From: Michael Eastham <Michael.Eastham@arun.gov.uk>
Sent: 05 August 2020 14:59
To: Planning Scanning <Planning.Scanning@arun.gov.uk>
Subject: FW: Planning Consultation on: BN/57/20/DOC

Please see the email below from ADC Drainage Engineers regarding discharge of condition application BN/57/20/DOC for the Lillies, Yapton Road, Barnham.

Condition 6 – Surface Water Drainage Design

FILTER DRAIN BAGWORK HEADWALL

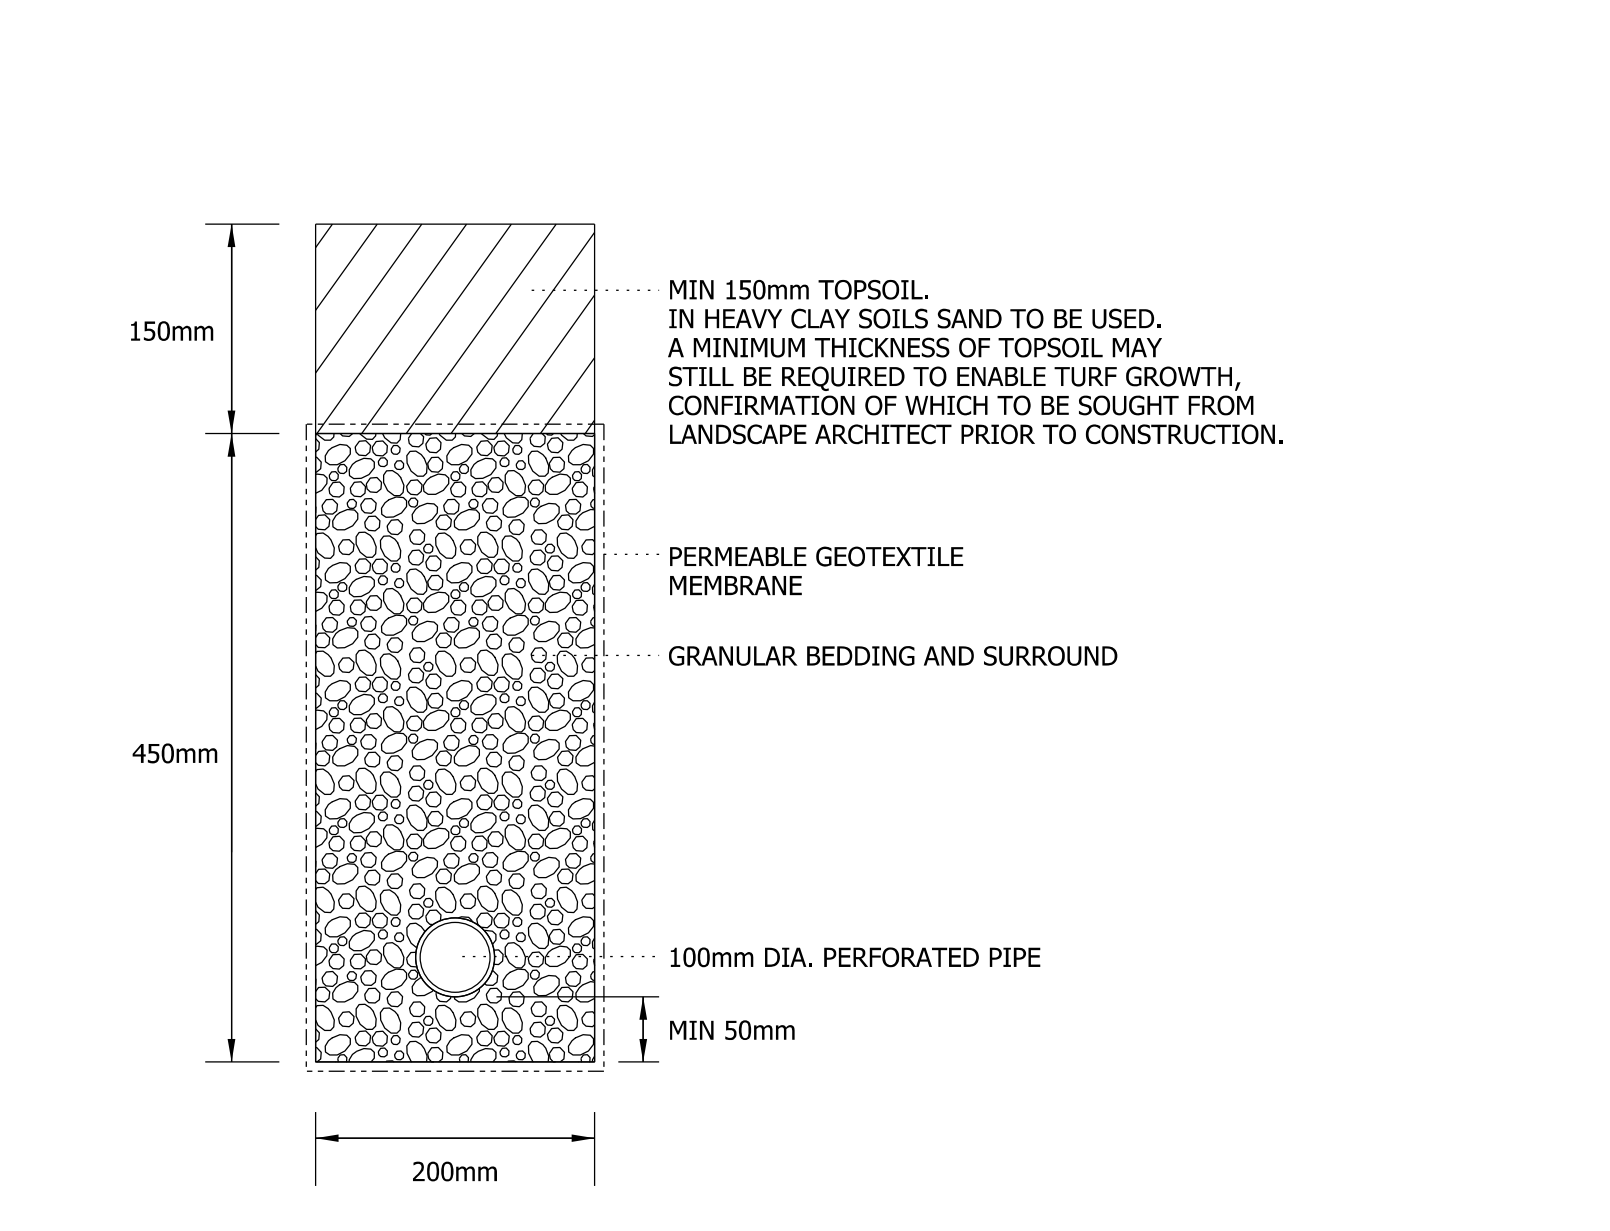
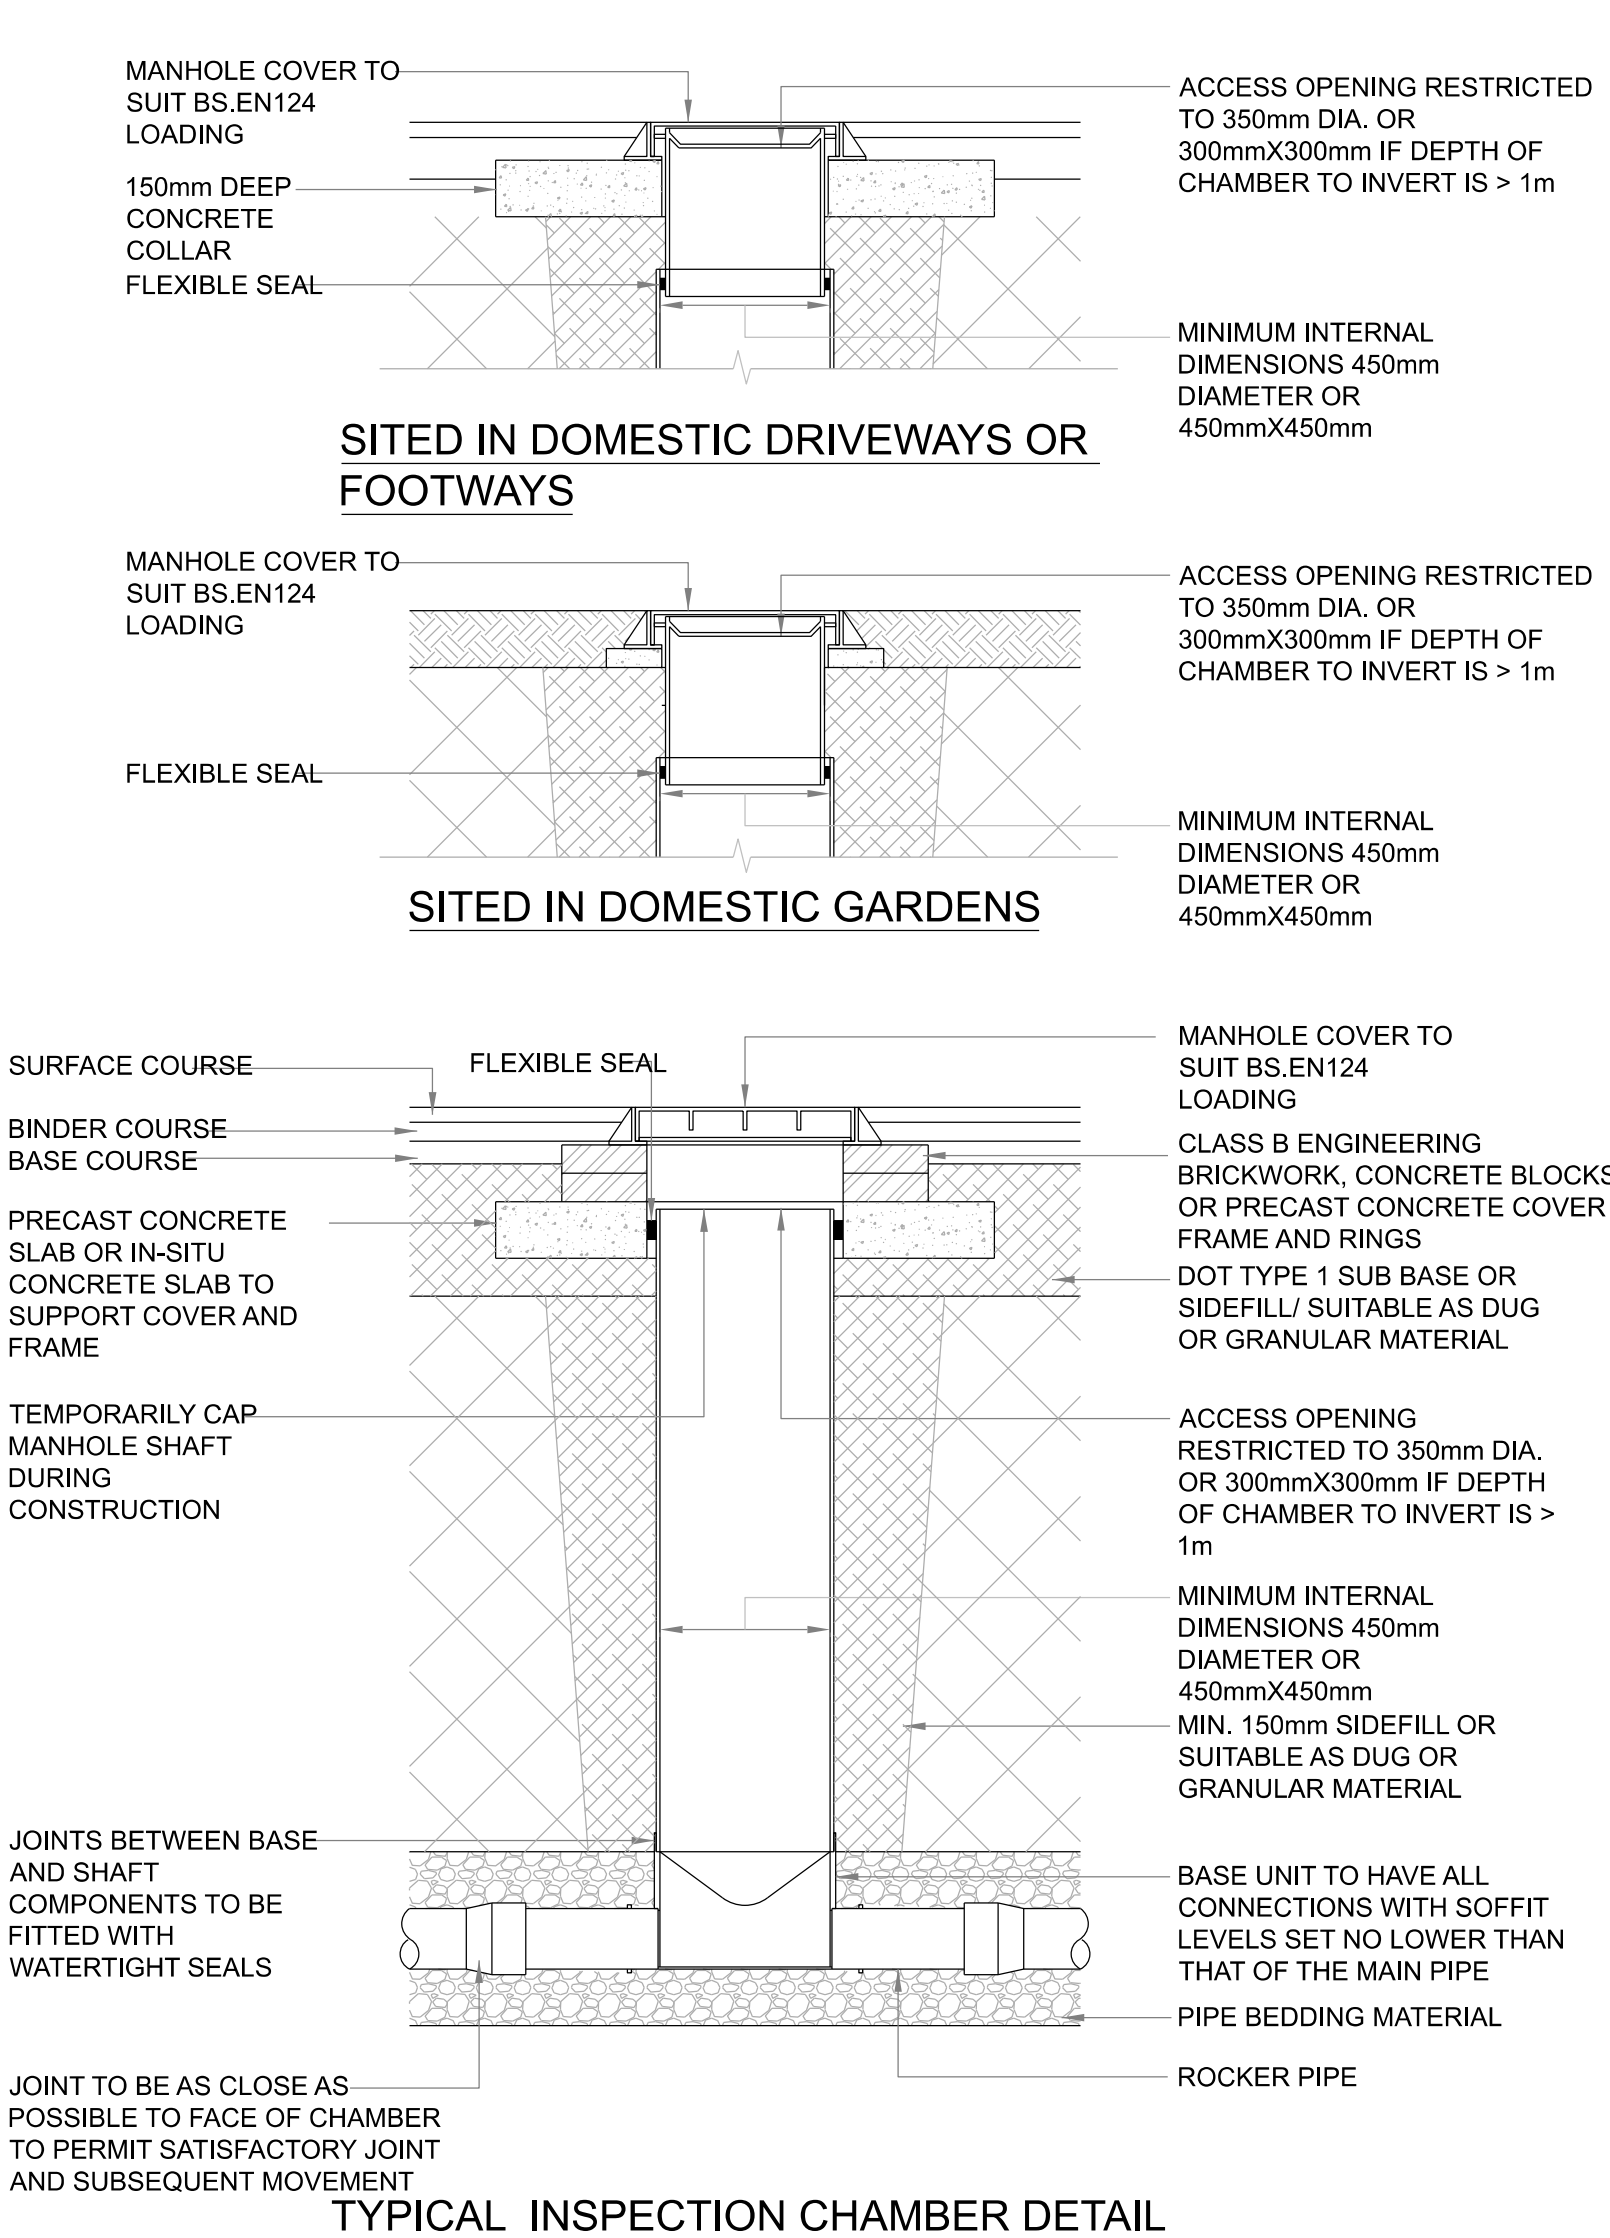
20. Please provide further detail of granular material proposed for filter drain. Type B filter material in accordance with SHW. Provide details on construction detail drawing. Please indicate ditch invert level at proposed point of connection to watercourse. The topo is shown on the drawing. It does not require further levels to be added. *Please provide details. Awaited*

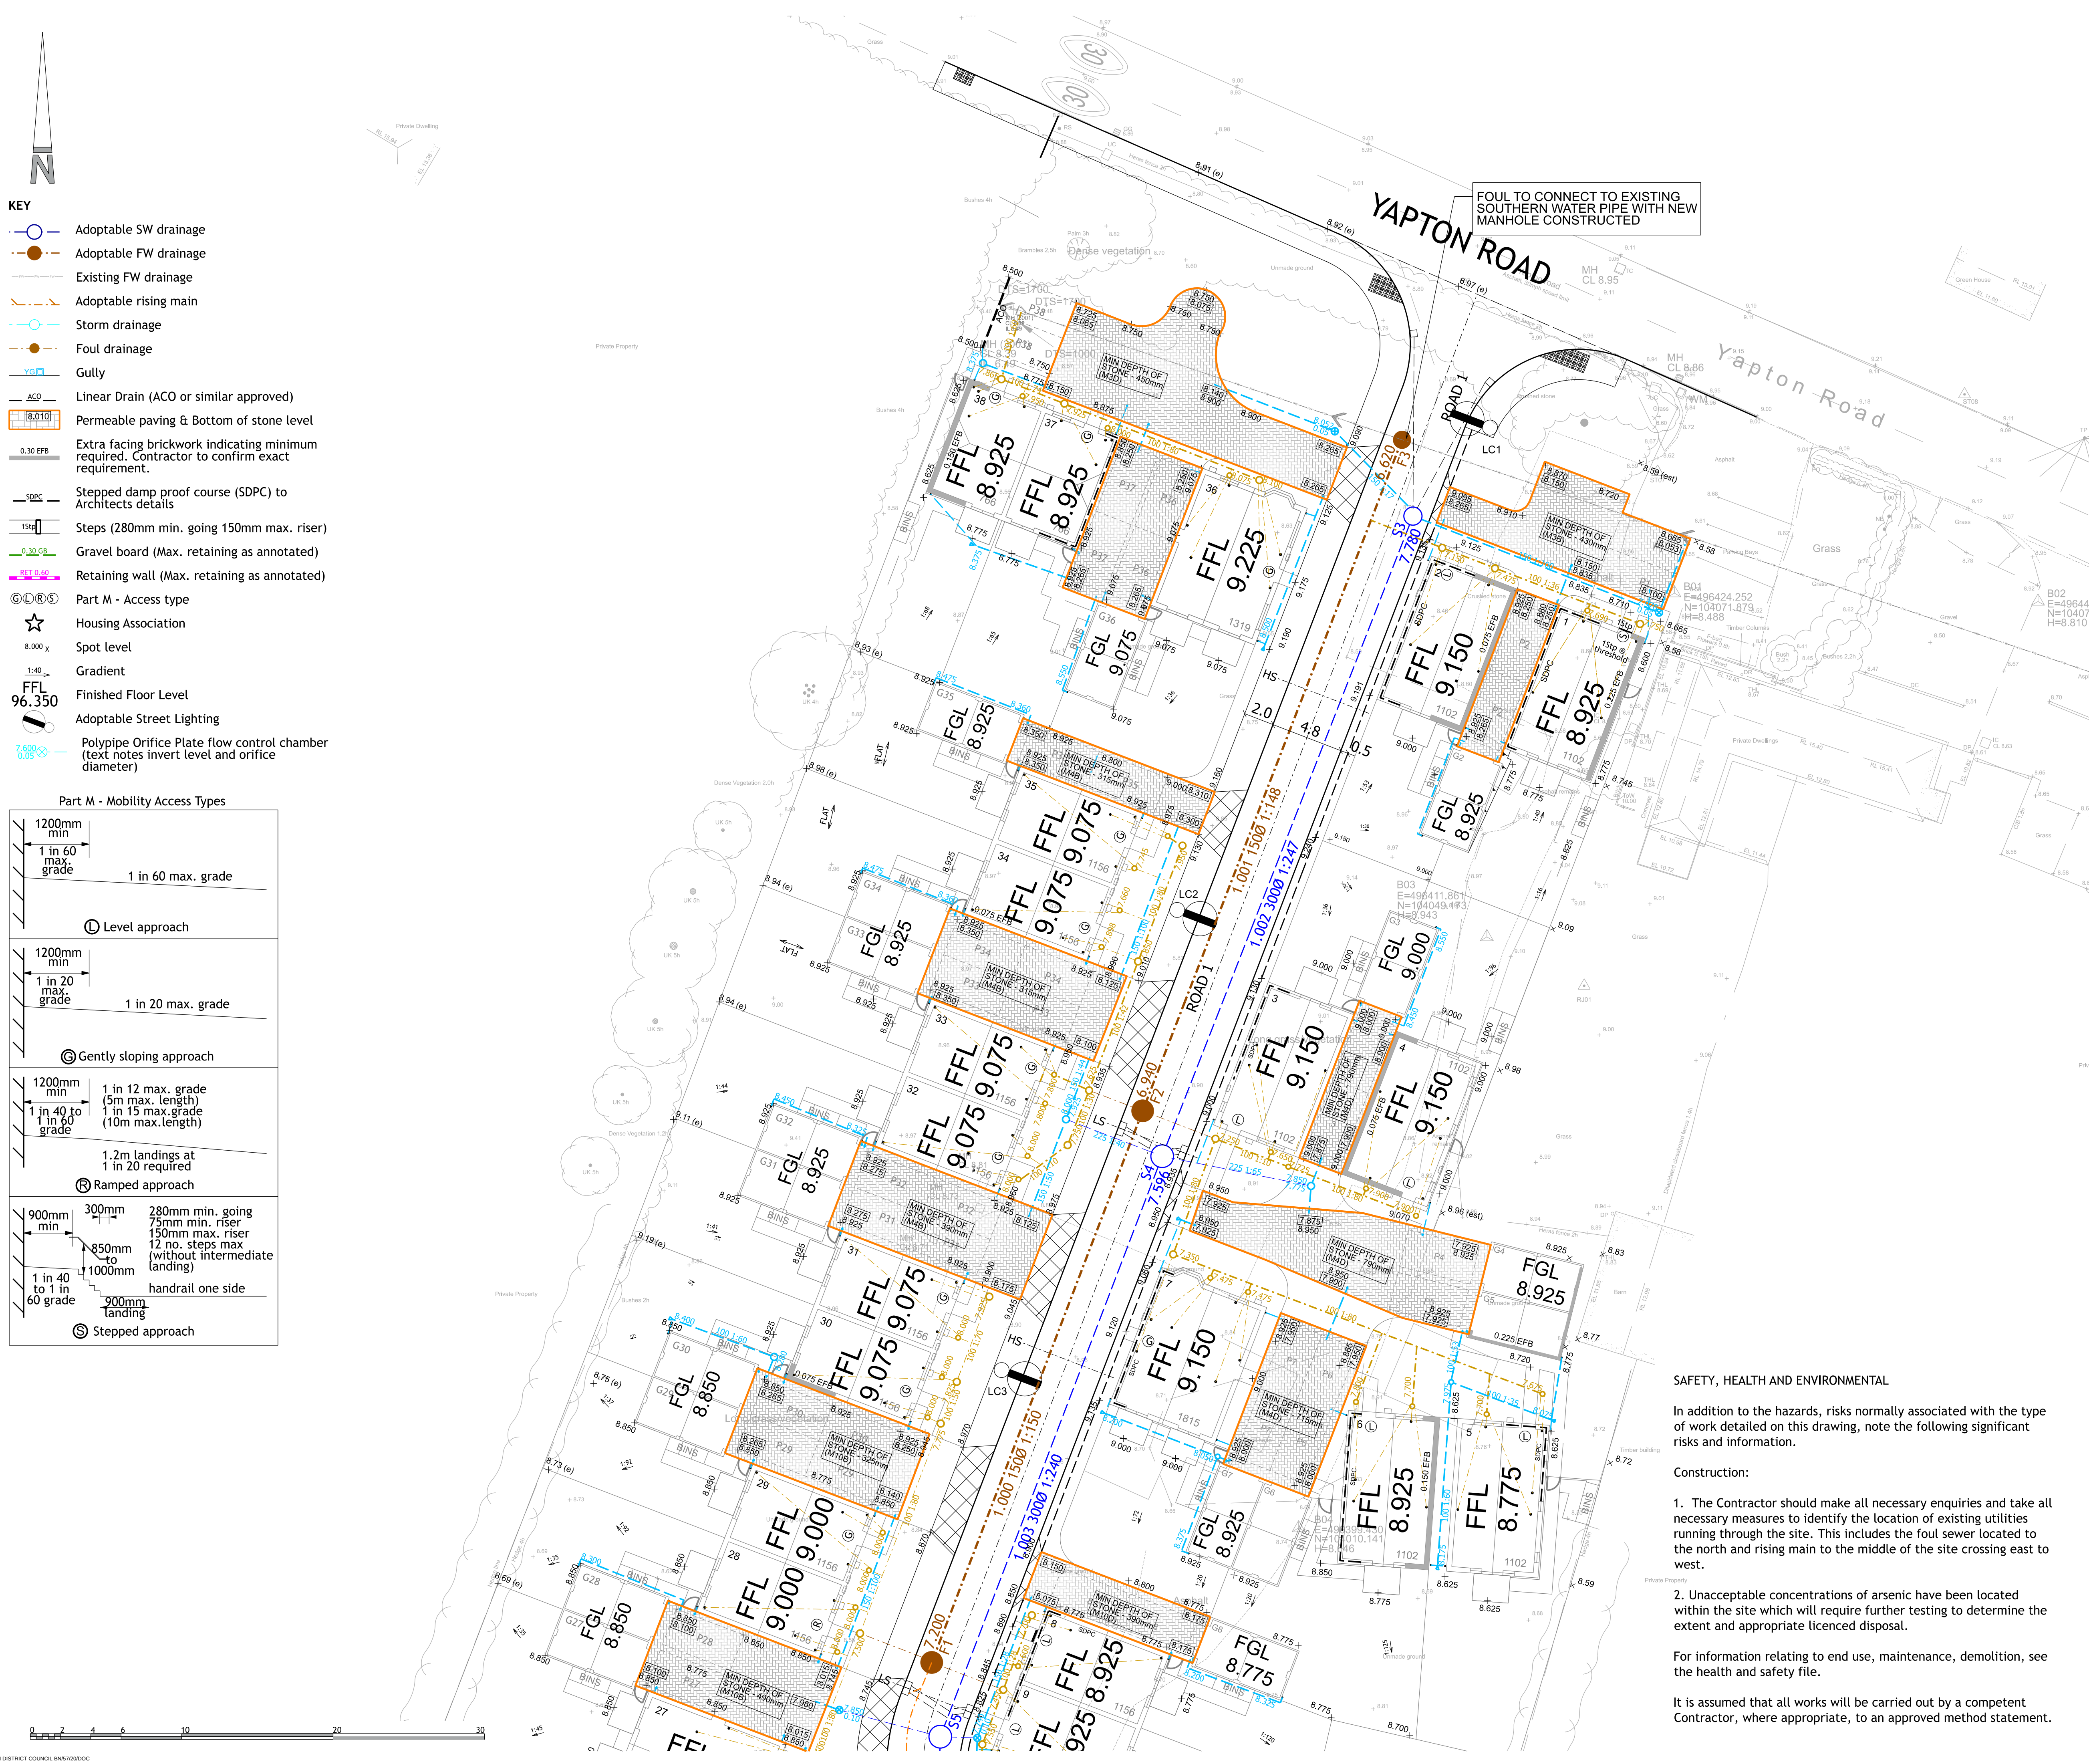
3. No consistency between orifice invert levels on plan and those shown on drawings. Please update calculations or drawings. *Updated drawings/calcs attached. Updated calculations with surcharged outfall awaited. Node 108 and Node 328 still inconsistent.*

4. Porous car park area invert levels and sub base depths in calculations are inconsistent with those shown on plan. Please update calculations or drawings. *Checked and updated. Note in the the manhole number in brackets on the plan depicts the manhole the porous car parks have been modelled on. Also where there are connecting areas, the mean average of the minimum depths have been used. To be reviewed with revised calculations.* I note your comment, but what has been modelled is not accurate, with invert levels of paving modelled typically lower than those on plan, this could result in flooding being underestimated. Dummy manholes should be added to represent permeable paving areas with invert levels set to minimum formation level and cover levels set to minimum finished level. Porous car park area 3D appears to have areas where the formation level is lower than the outgoing pipe invert level, please ensure outgoing pipes are at low points.

5. Where is porous car park manhole 4 in calculations? *Please refer to plan and referenced manhole number* Where is porous car park 4d in calculations?

6. Porous car park m10 is 4 separate areas, with two different orifice controls. Yet this is modelled as one porous car park area. This is not appropriate, please calculate as separate structures. *Checked and updated.* To be reviewed with revised calculations. Separated into two areas, but still issues with levels modelled.

17. Please detail how ACO drain near hydrobrake connects, this is not clear. *It connects into private lateral as you would expect of private parking bays. Make clear on plans, must be clear to ensure constructed properly. Awaited*
